Ribble Valley Borough Council
Council Offices
Church Walk,
Clitheroe
Lancashire
BB7 2RA

Phone: 0300 123 6780
Email: developeras@lancashire.gov.uk
Your ref: 3/2026/0315
Our ref: 3/2026/0315/HDC/KW
Date: 15 October 2026

Location: Land off Chatburn Road, Clitheroe BB7 4JX
Proposal: Residential development of 39 dwellings with associated landscaping, car parking and access.
Grid Ref: 375365 443101

Lancashire County Council acting as the Local Highway Authority, does not consider that the application as submitted fully assesses the highway impact of the proposed development and further information is required as set out in this response.

Proposed Site Layout

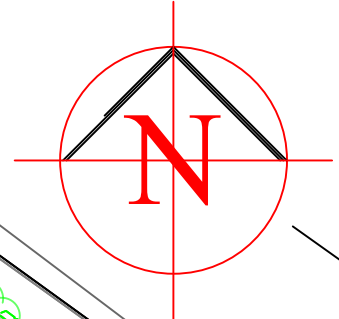
The development forms a loop around the site; however, the loop comprises both a spine road and a shared access road fronting Plots 32-39. Refuse collection vehicles often avoid private road layouts of this nature and the proposed arrangement may therefore present operational difficulties for refuse collection in the future. This matter should be discussed and agreed with Ribble Valley Borough Council's refuse collection team prior to determination of the application. The developer has not amended this aspect of the layout and wishes to retain the shared access road fronting Plots 32-39. Should the refuse collection team consider the arrangement unacceptable, an alternative solution should be explored, such as designated bin collection points or amendments to provide a continuous carriageway design around the full loop of the site.

The LHA remains of the opinion that this layout should be updated to adoptable layout standards, even if it is to remain private, in order to provide a consistent road hierarchy

throughout the development. This would mean designing the main spinal road to at least 5.5m wide and providing 2m footway provisions on both sides of the carriageway.

The LHA has reviewed the proposed internal layout as shown on the submitted drawing number T4832-H-01, Rev P1 within Transport Note 1 (dated 24th August 2026). The development is arranged around a main loop road with a number of short private drives and shared access drives serving groups of dwellings. While the road layout provides connectivity throughout the site, the LHA maintains the view that the shared access road design fronting plots 32 – 39 should form a continuous formal carriageway design creating a clearly defined primary loop road around the site. It is noted that the developer does not support this view.

The carriageway widths do not accord with the Local Highway Authority's design standards, which typically require a minimum 5.5m wide carriageway for two-way residential streets. It is understood that the applicant is of the view that the development is to remain private and as such does not wish to widen the carriageway from 5m.

2m wide footway provisions have been provided on both sides of the access and a 2m footway has been provided along the inside of the internal loop road where it then terminates at the corner of plot 32 and on the opposite side at plot 39; the rest of the site does not benefit from the same provisions. Whilst the site access is shown to have tactile paving on either side, no such provisions are shown from the access to the internal footway, which is opposite the access. Drop kerb and tactile paving arrangements should be provided from the access to the internal footway provisions to be in line with inclusive mobility guidance.

Whilst the LHA understands that the developer wishes to keep the site private, the LHA's concerns regarding pedestrian connectivity within the development have not been addressed. Whilst a single footway arrangement may operate within the adjacent development, this does not negate the benefit of providing continuous pedestrian infrastructure on both sides of the carriageway. The LHA remains of the view that footway provision should be reviewed, particularly between Plots 1-9 and 22-28 and around turning heads, to improve accessibility, pedestrian convenience, and route continuity throughout the development.

Examples of where further pedestrian access should be considered are areas where driveways are bound with neighbouring properties' driveways, such as plots 24 and 25, as well as plots 18 and 19. Areas such as this can result in access conflict between neighbours relying on third-party land to provide additional width for doors opening and pedestrian access when other vehicles are parked. As such it is recommended to provide a shared path between third-party driveways.

The LHA has reviewed the Proposed Amenities Plan, drawing 067/P/08, Revision A, and understands that most of the dwellings will be provided with Electric Vehicle Charging Points; however, it would appear some dwellings do not have provisions, such as plot numbers 20 and 21 as well as plot 24. Cycle storage also appears to have been shown to be provided across some plots such as 18 – 22. However, there are sections of plots which do not show the provisions such as plots 32 – 39. The LHA would expect all dwellings to be provided with both an electric vehicle charge point and secure cycle storage.
